Consultation Response from KC, Trees
2023/93704 land northwest of, Urban Terrace, Denby Lane, Grange Moor, Huddersfield, WF4 4EB
Erection of 10 dwellings and associated works
Date Responded: 09/04/2024 Responding Officer: D. Atkinson Responding Ref:

**Denby Lane,
Grange Moor**

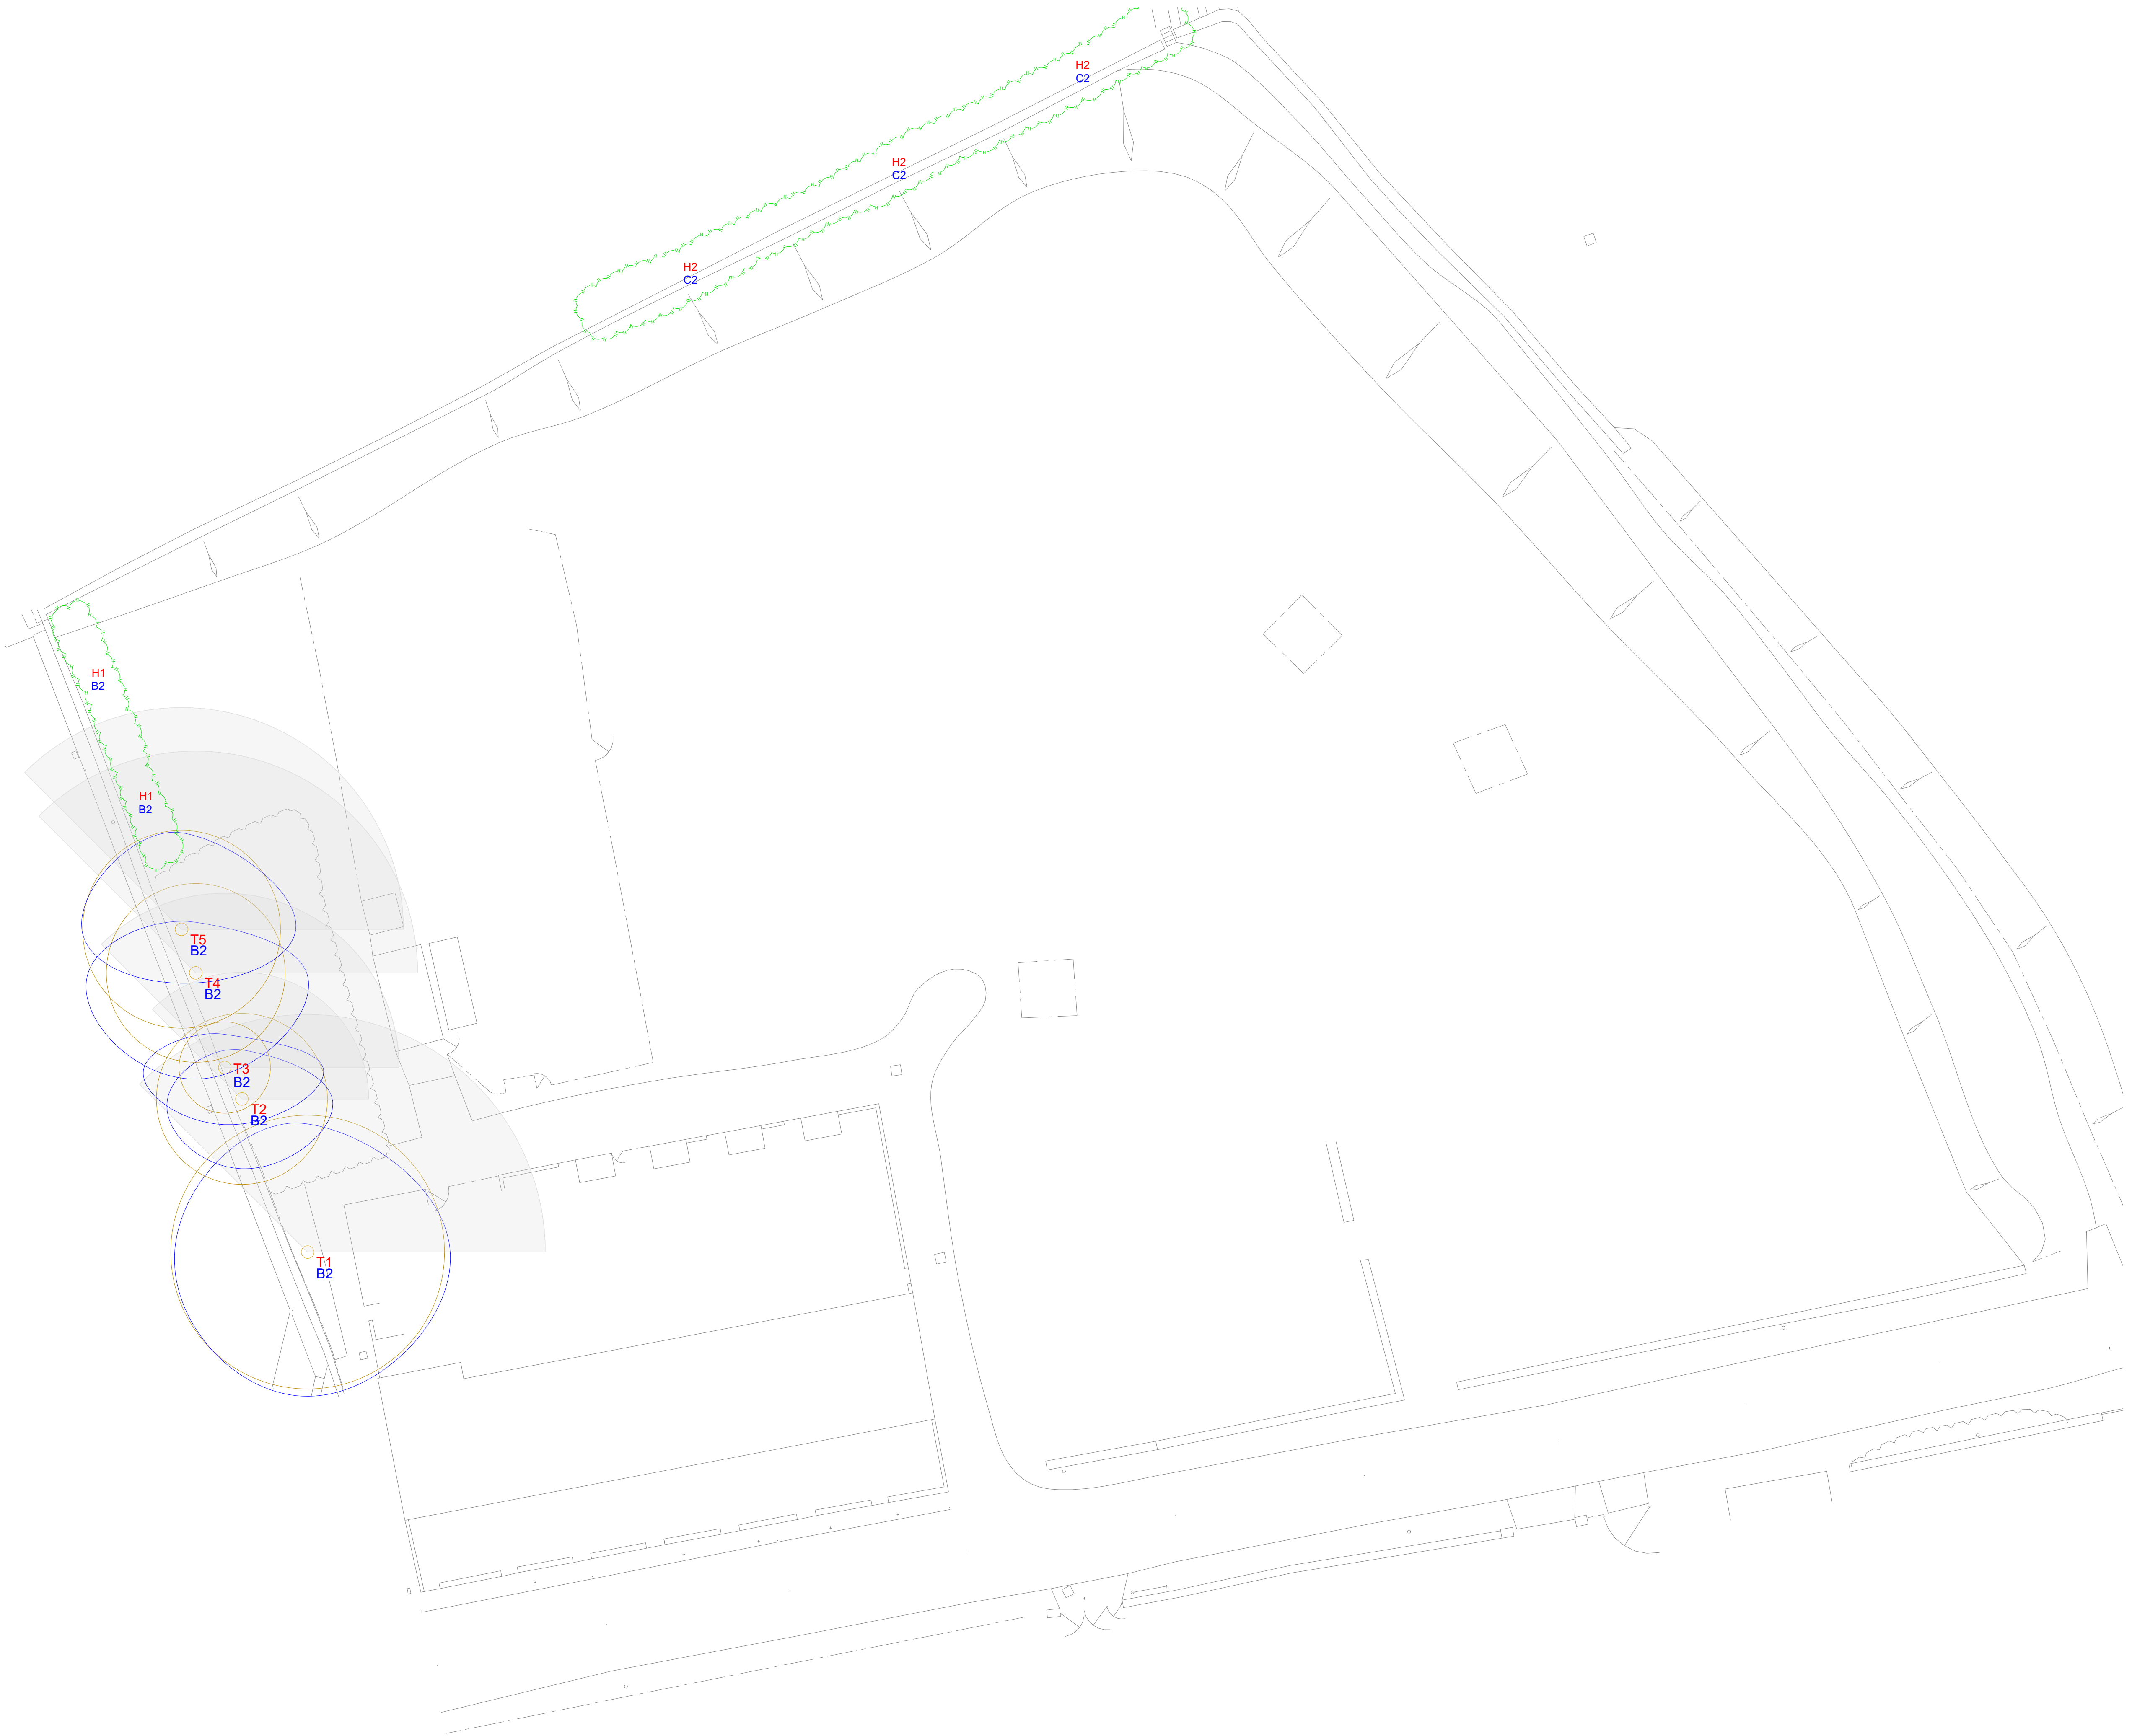
There is no objection to the proposal from a trees perspective, subject to a condition for the Arb Method Statement and Tree Protection Plan submitted (November 2023) be updated to match the most up to date version of the proposal and then implemented during the construction.
